Adrian Hatton – Affected party.

I own all the private land within Land Plan 7, with exception of Plot 7/6e. I and my business will be significantly affected by A46 scheme FCA at Kelham.

Issues raised at CA Hearing on 3rd December 2024:

DRAWING TITLE
 GENERAL ARRANGEMENT PLANS
 REGULATION 5(2)(o)
 SHEET 7 OF 7

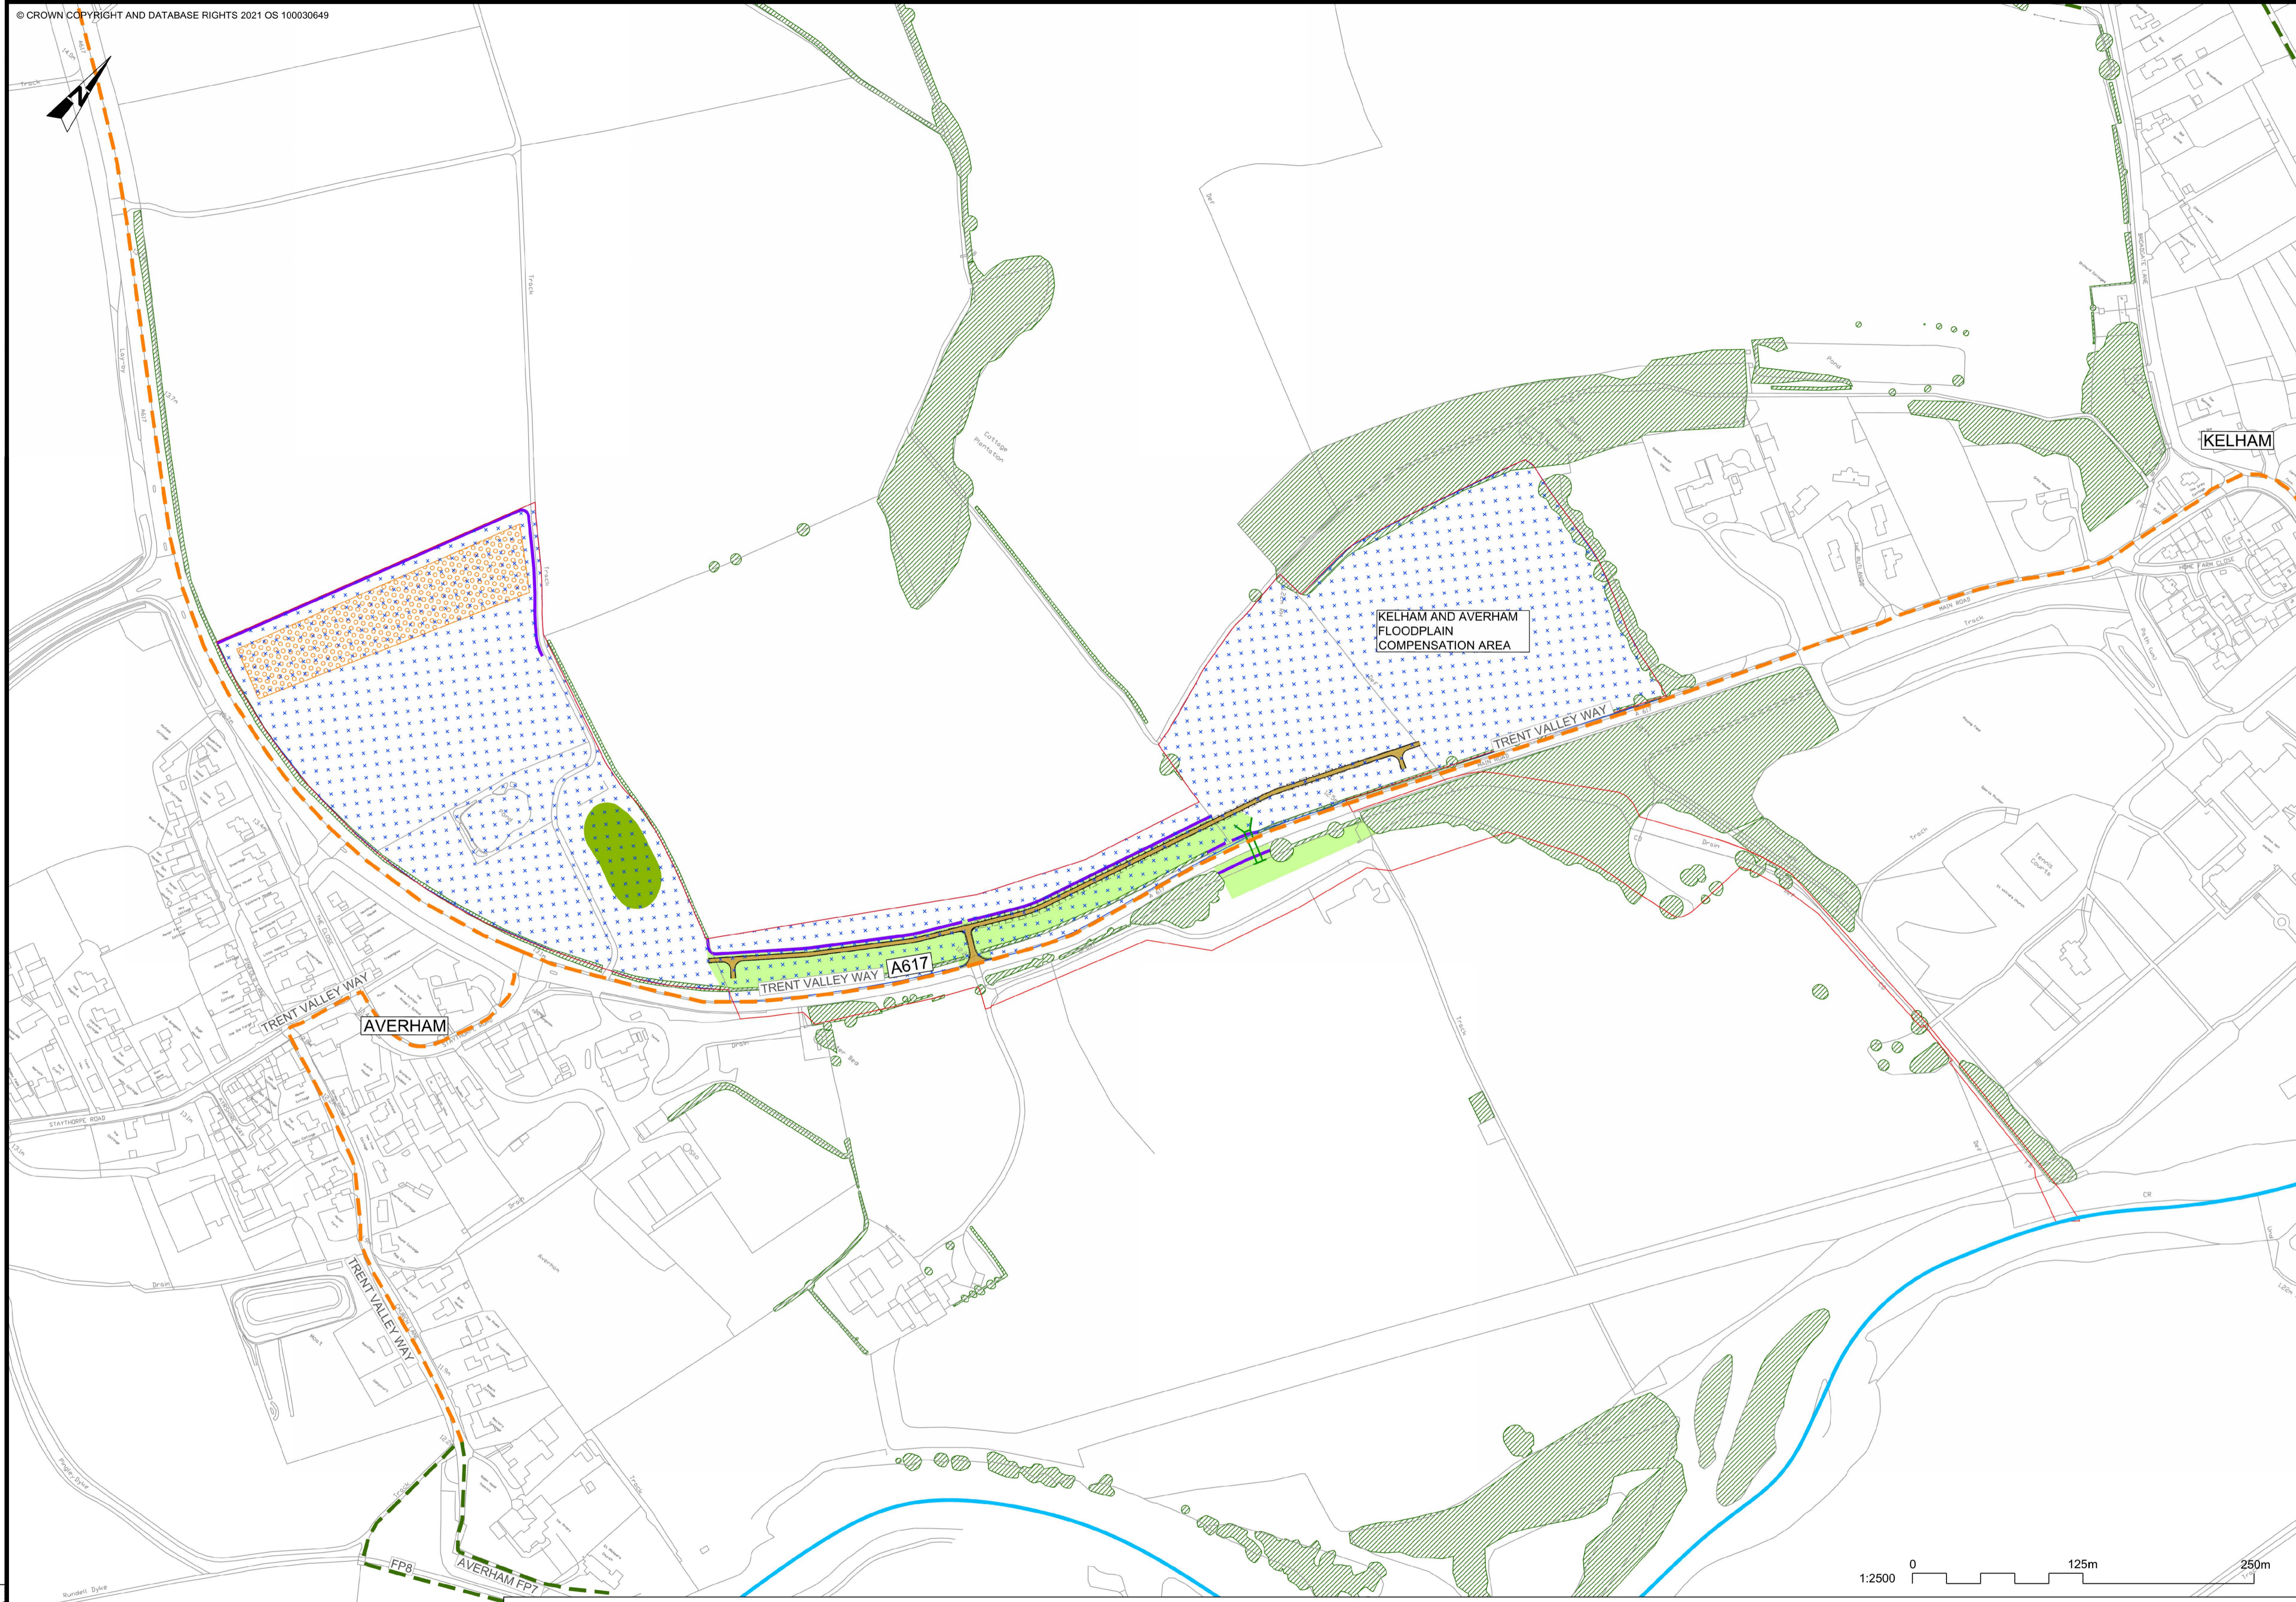
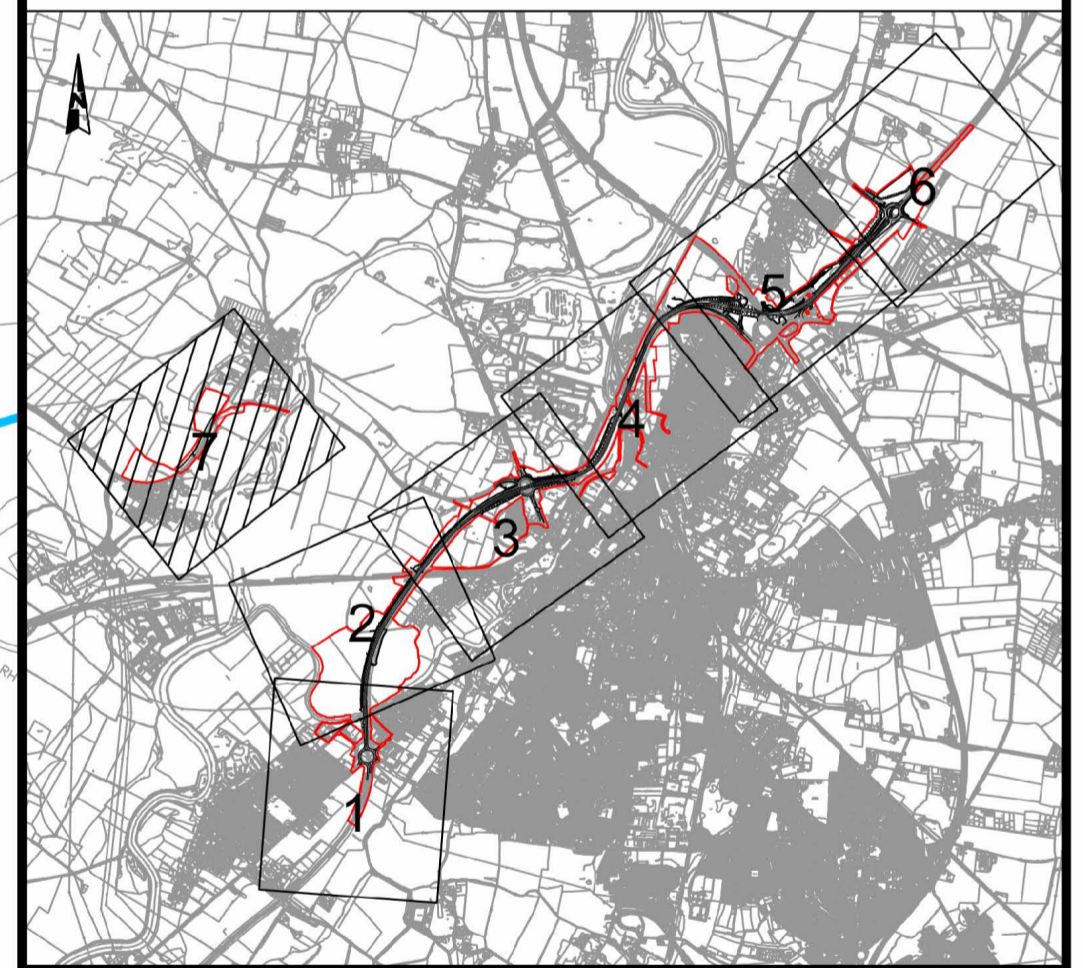
- ii) For the Kelham FCA to work, in addition to culvert work beneath the A617, it requires suitable enhancement of existing drainage system on land East of A617 to ensure free flow of water to and from the FCA with no adverse effect on that land. For example, neither General Arrangement Drawing TR010065, sheet 7 of 7 nor works plan Sheet 7 (REP 3-002) show the presence of the bridge and location of the single (c.250mm?) diameter culvert passing beneath a farm access within Land plot 7/2d – this would have to carry a good proportion of flood water to and from FCA East of A617 – I would welcome details of how it is proposed to upgrade that ditch and culvert to cope with expected volumes of water.

- iii) The DCO plans omit the presence of field access off A617 at SE corner of Red House Field SK7655 8525 (within plot 7/4e) – there is no depiction of the existing gateway and access track on Applicant General Arrangement Drawing TR010065, sheet 7 of 7 (see Annex 2 below), nor is there recognition of preserving existing access points and providing appropriate bridges to afford safe pedestrian and vehicular passage over the Applicant's proposed hydraulic link channel at all times. Other access points depicted are incorrectly located on drawings.

- iv) General Arrangement Drawing, sheet 7 (see Annex 2) and Works Plan sheet 7 do not show the required new access to be constructed to East of A617 to provide access for construction and ongoing maintenance access of the A617 culverts and drainage system on East side of A617 to the Trent.
